**Consultation Response from KC,
Ecology Unit**

2020/92800 Land at, Pennine View/Pheasant Drive, Birstall, Batley, WF17 9LT

**Demolition of existing warehouse and workshop unit and the erection of 3 units with
reconfigured access, boundary treatment, landscaping and associated works**

**Date Responded:
02/10/2020**

Faunal Enhancements

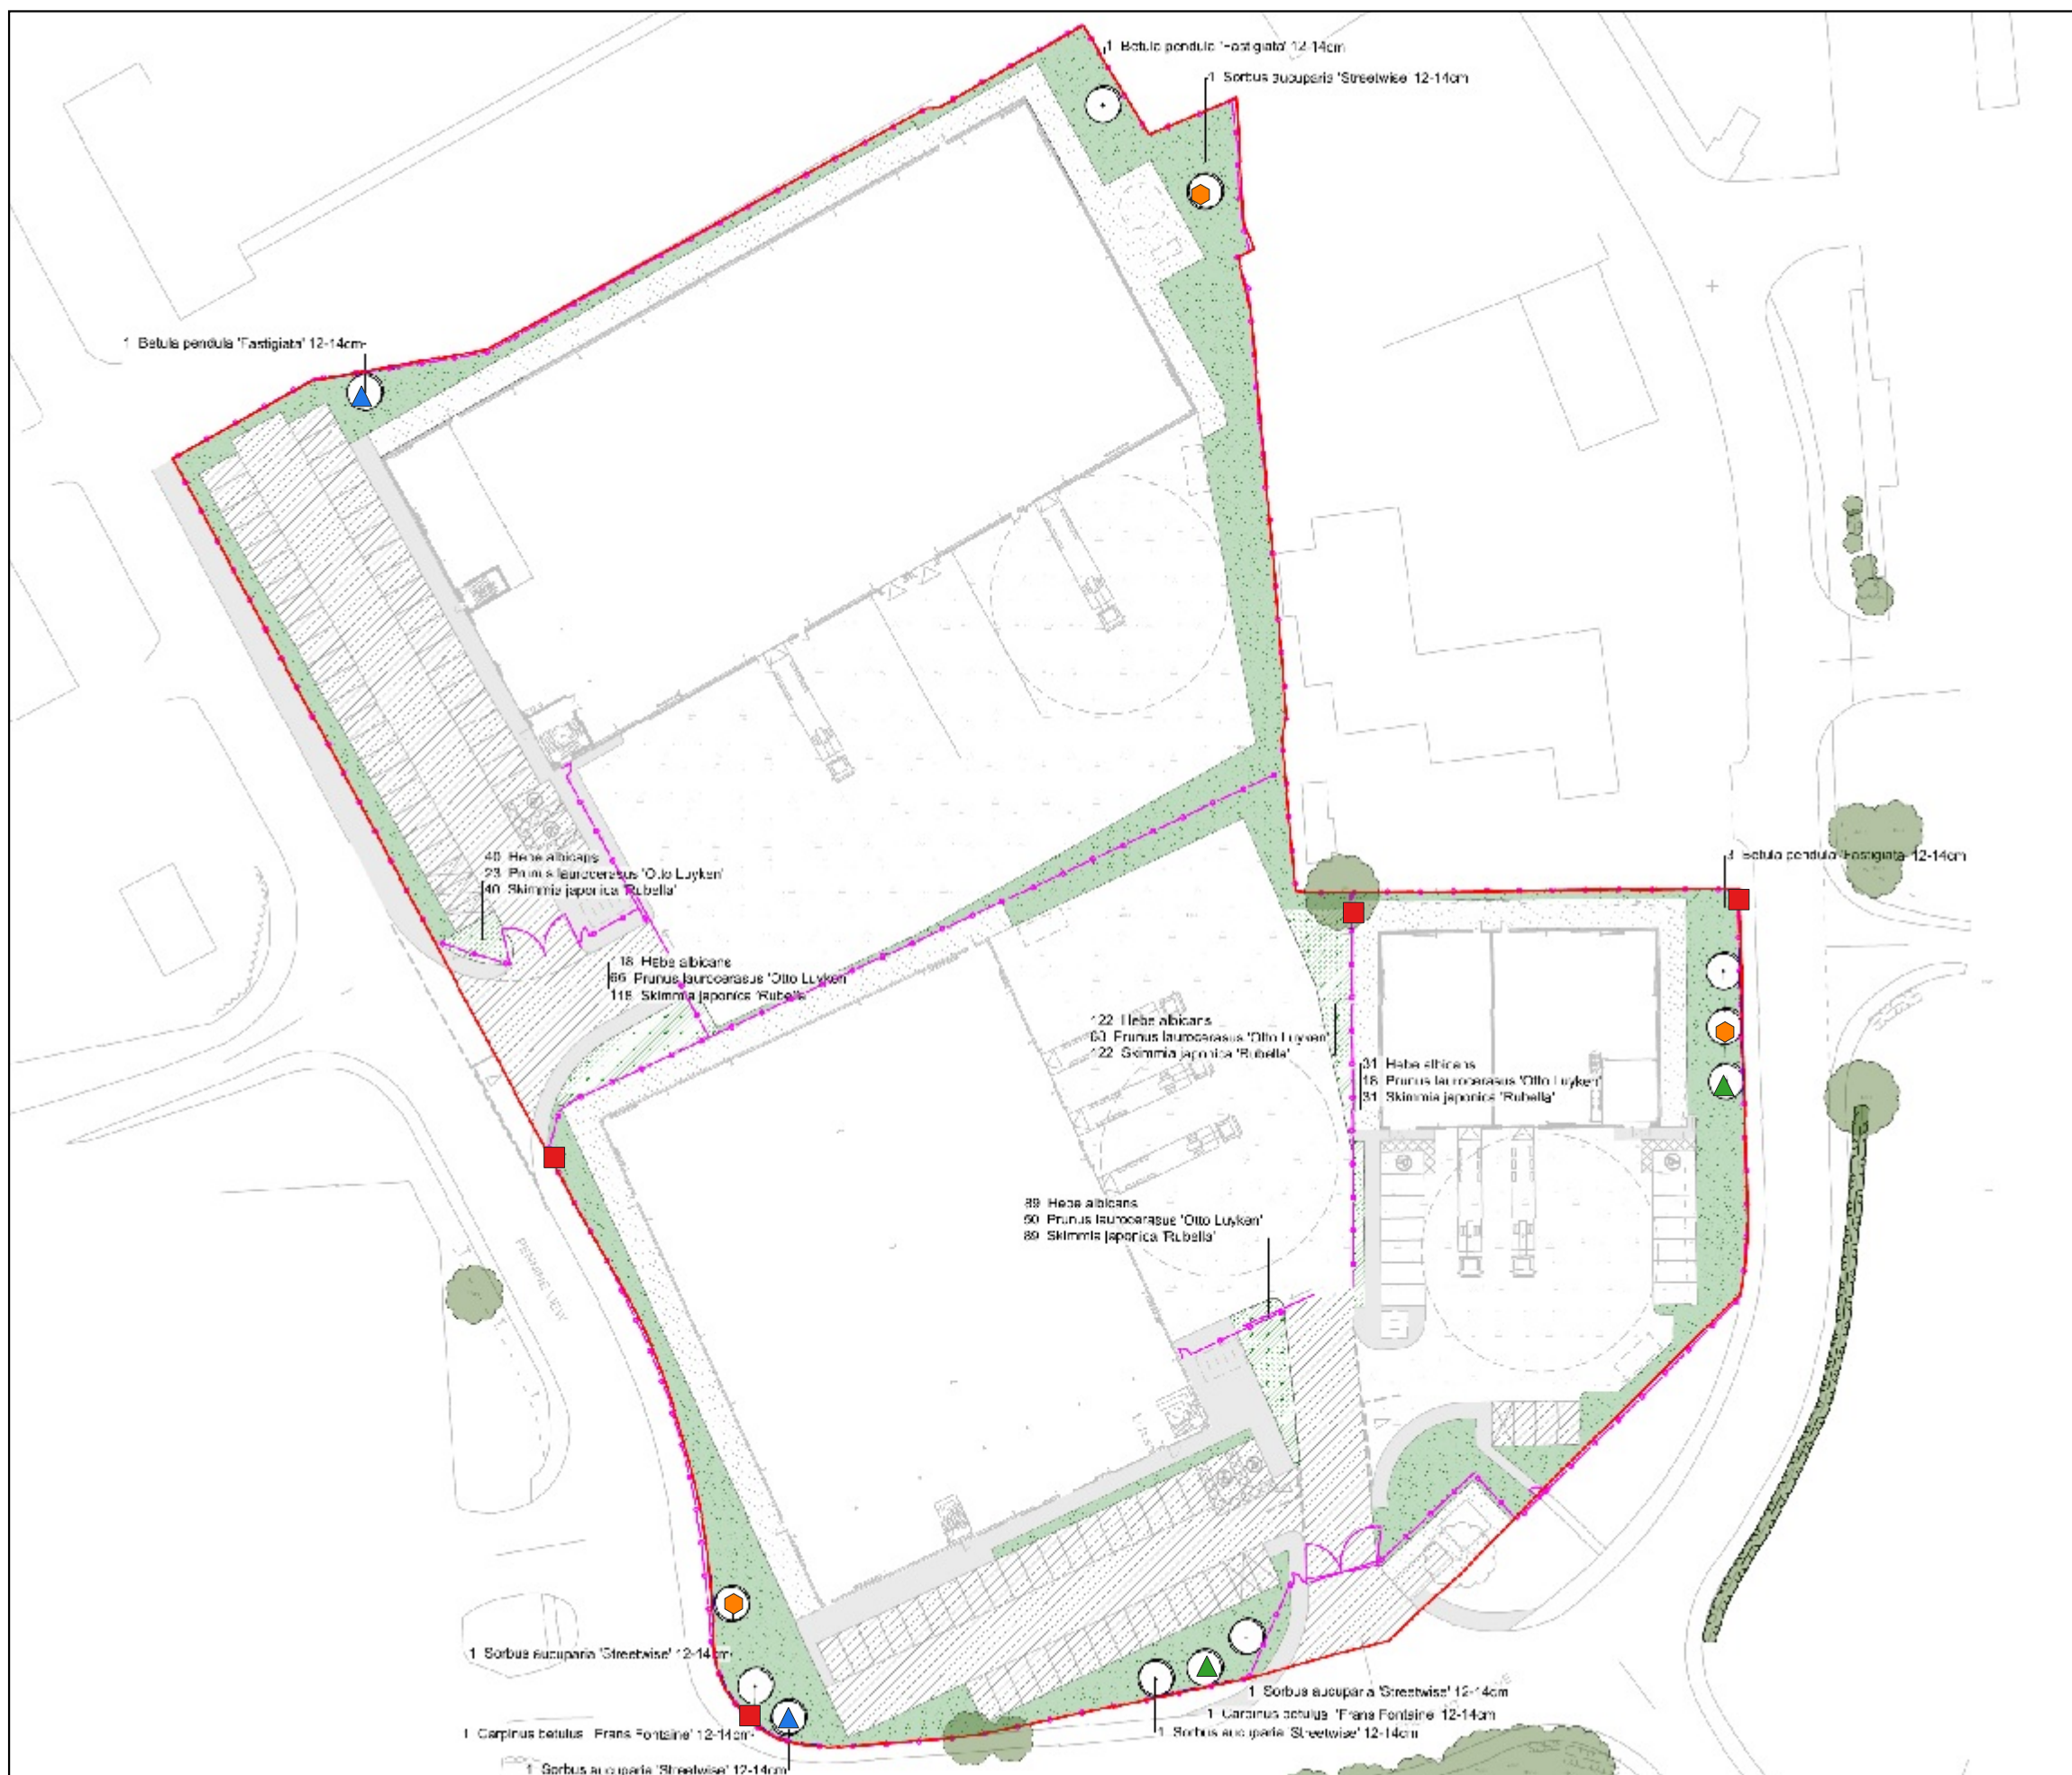
In addition to the above, as recommended within the corresponding ecological appraisal, protected and notable species should be considered within the BMP such as the inclusion of faunal boxes and boundary treatments which facilitate the movement of hedgehogs.

Additional measures should be incorporated into the BMP in order to demonstrate a 10% biodiversity net gain in the biodiversity metric. In addition, provisions for faunal boxes should be included within the BMP with clear site plans indicating their locations.
